PROJECT: MP 09_0146 MOD 4 - Modification to Eastlakes Shopping Centre
Mixed Use Development
RE: Response to Submissions 28.11.2019

Rory Toomey
Principal Design Excellence
Government Architect NSW

4 SHADOW STUDY  
JUNE 21 EST SOLSTICE 12:25 PM NTS

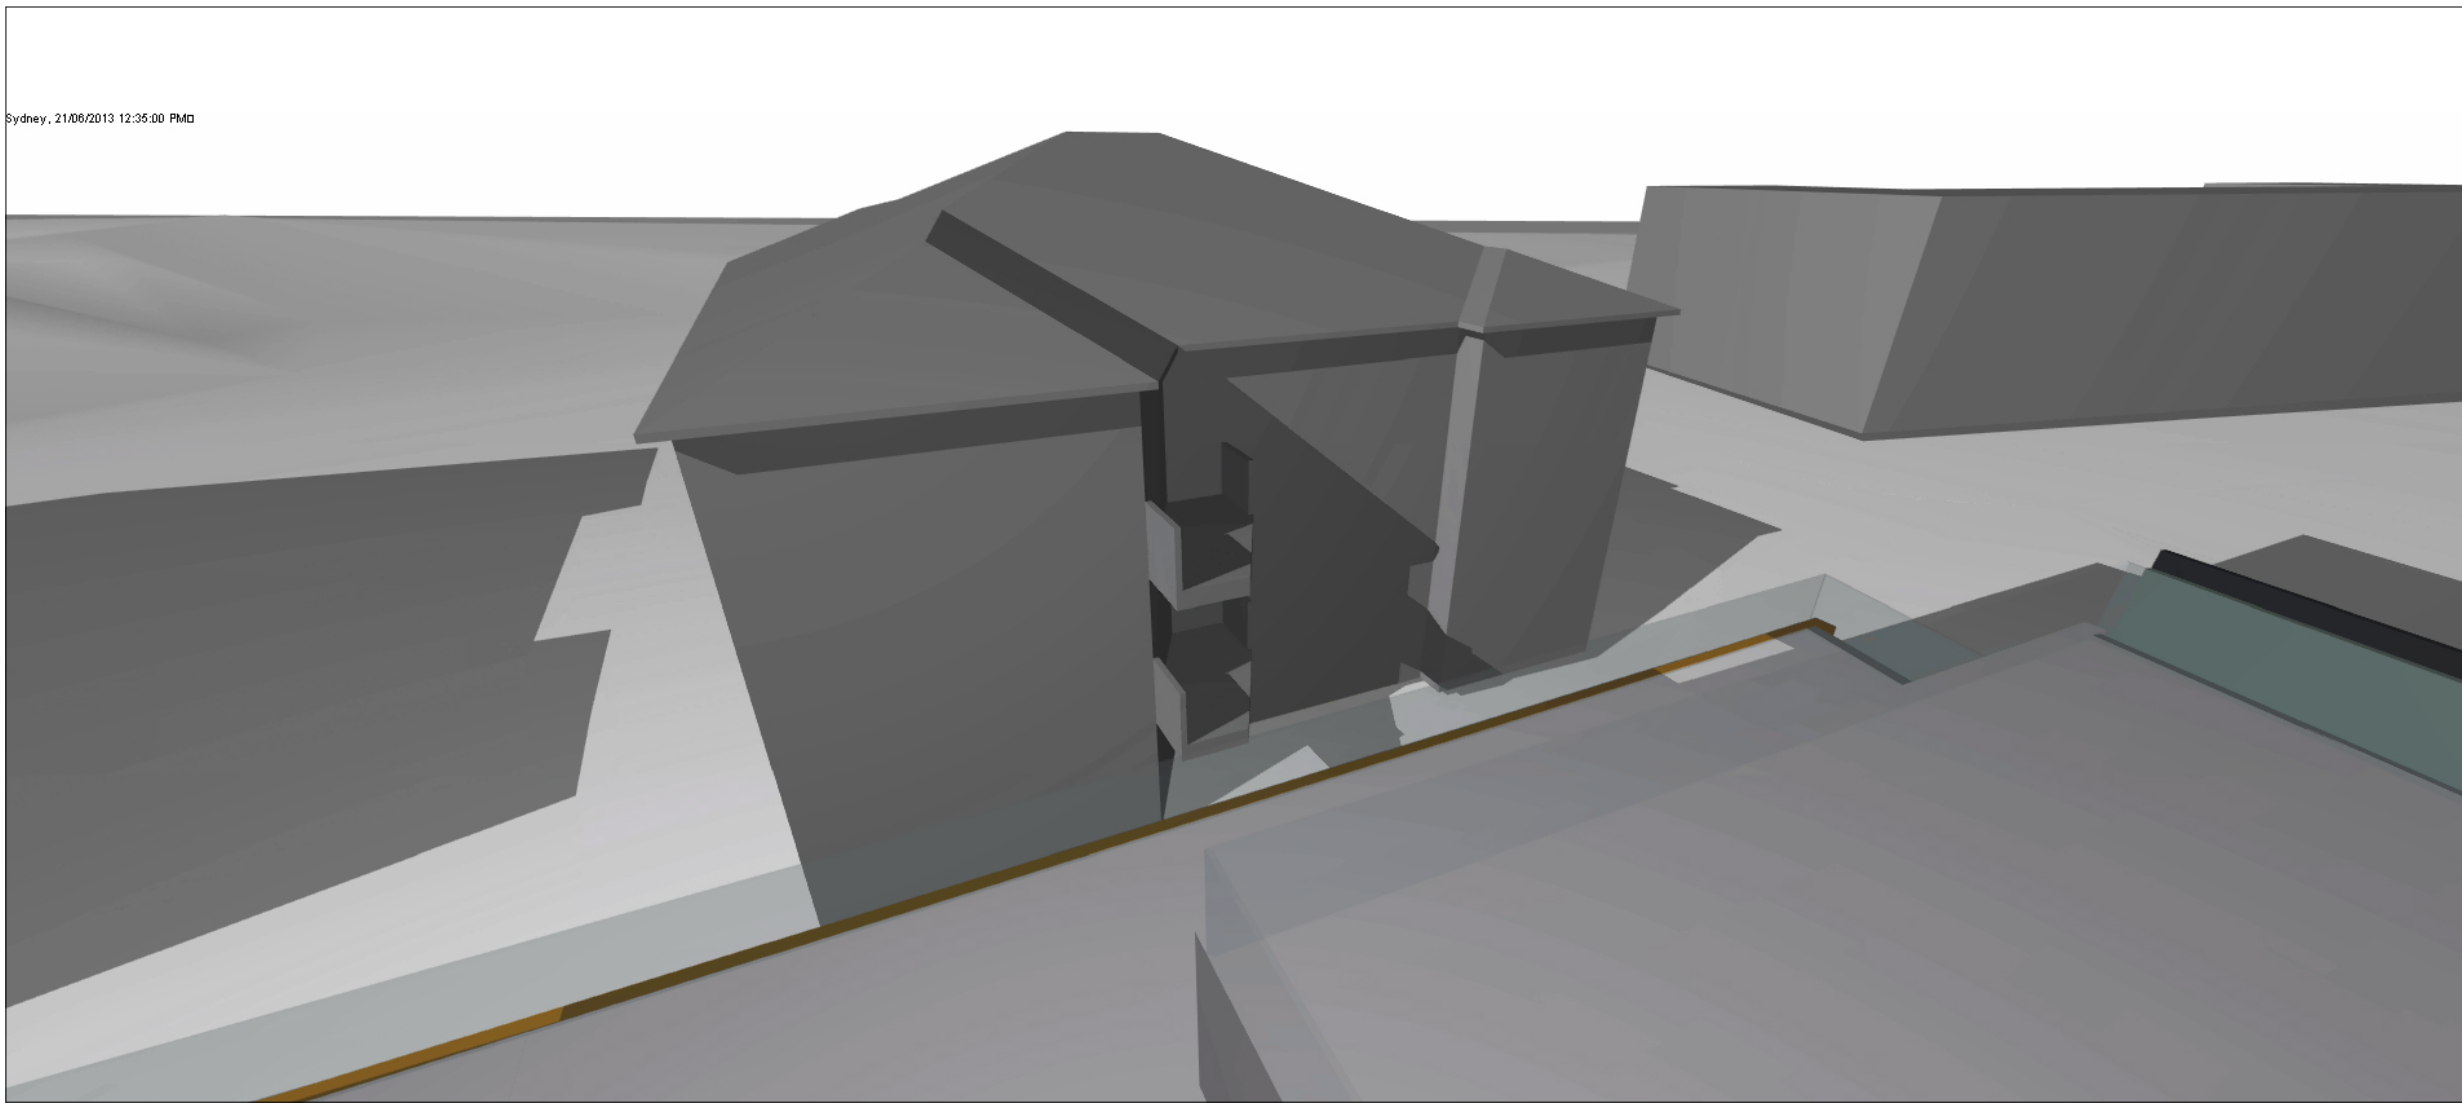
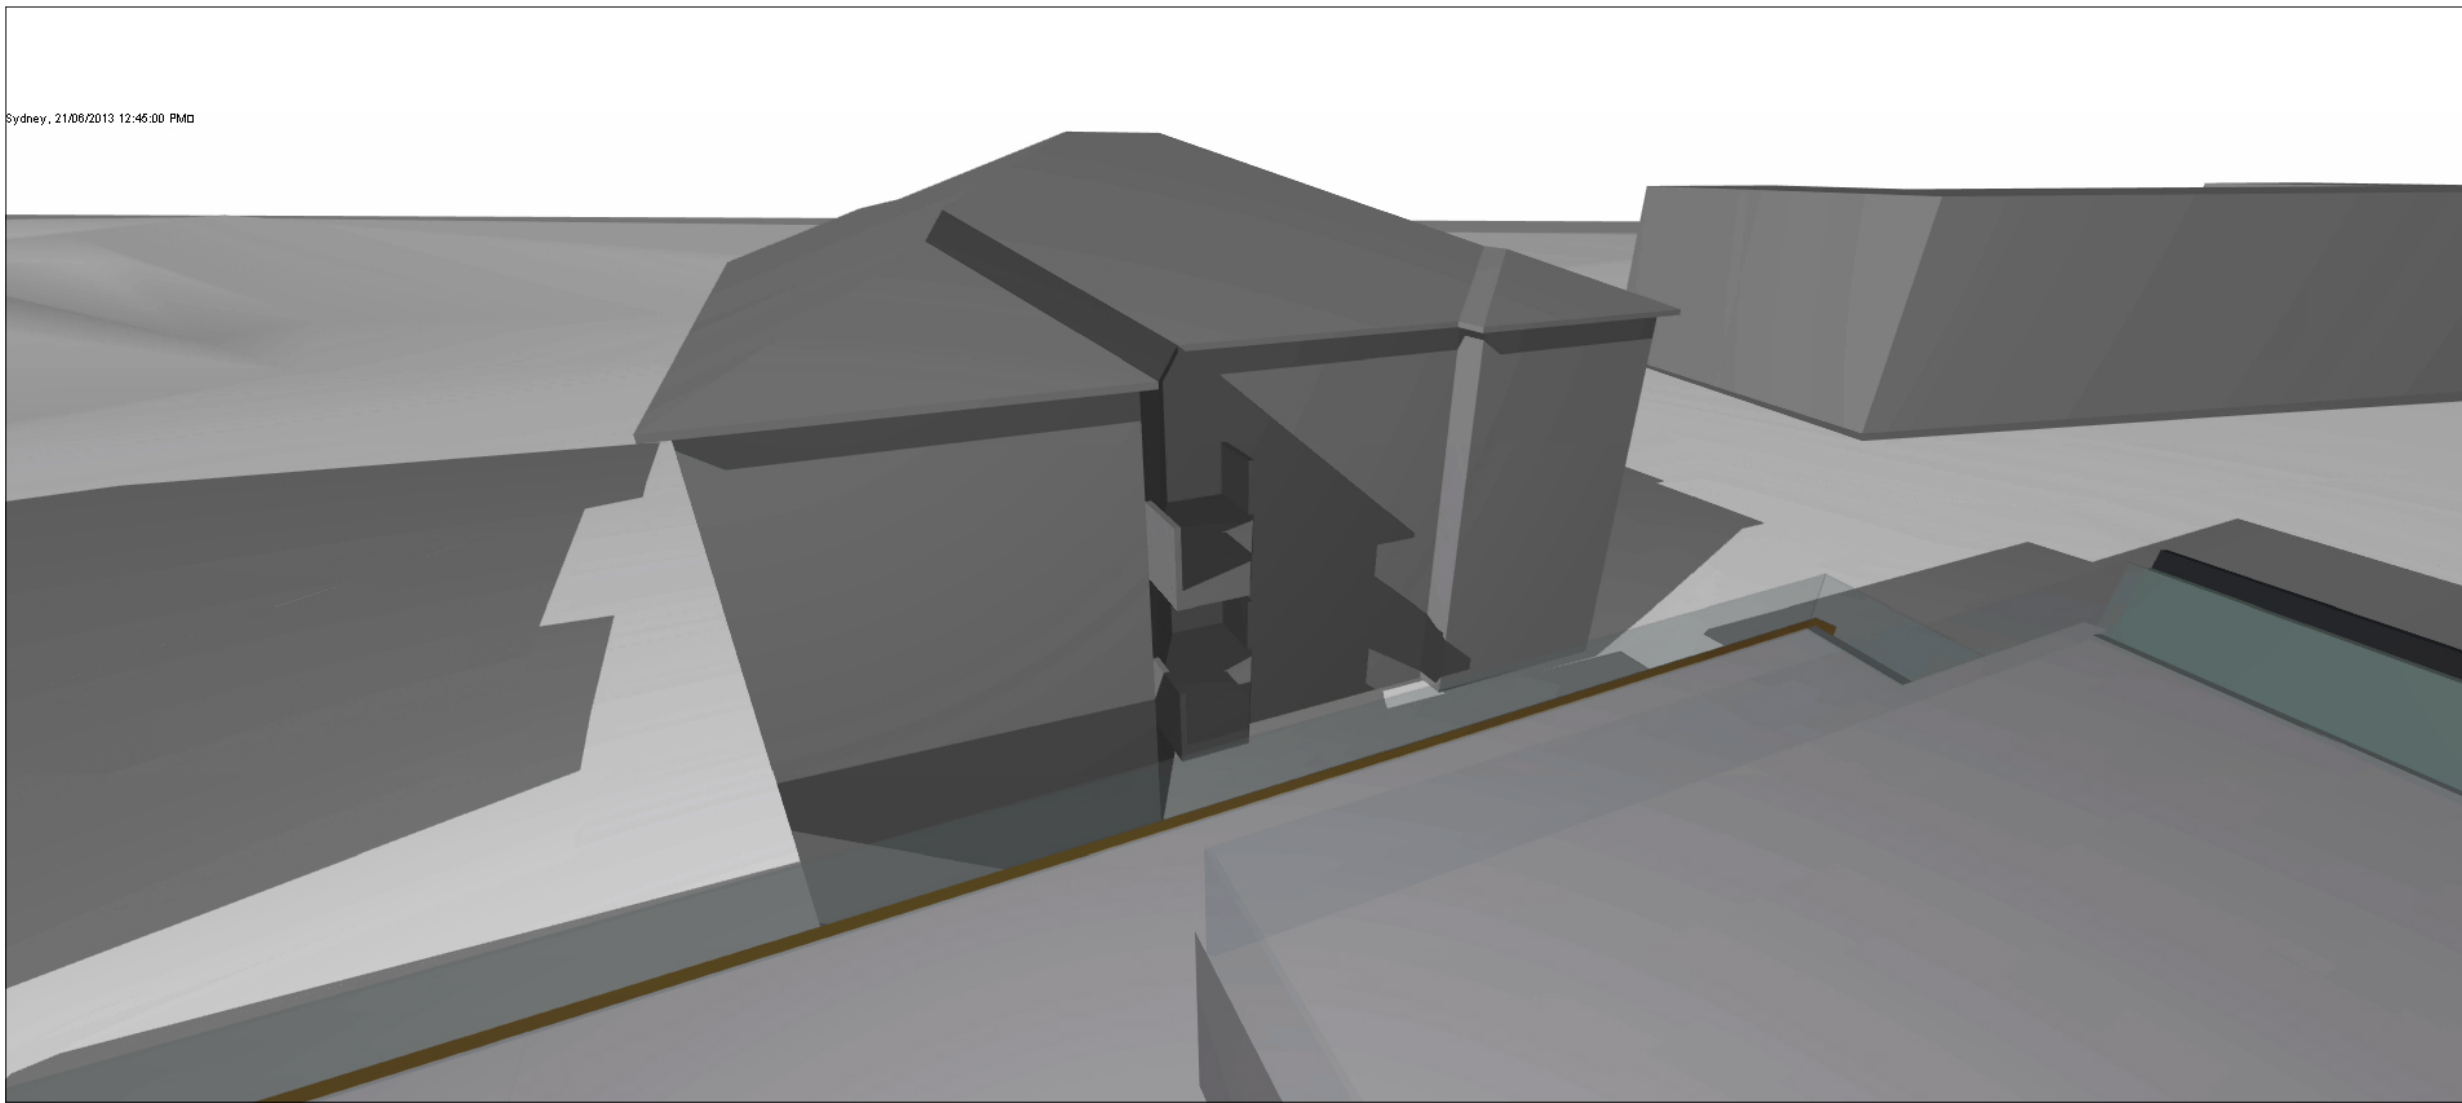
They demonstrated 2 hours of solar access to neighbouring properties and the treatment of the 'back of house' side of the project at street level is an improvement on earlier iterations.
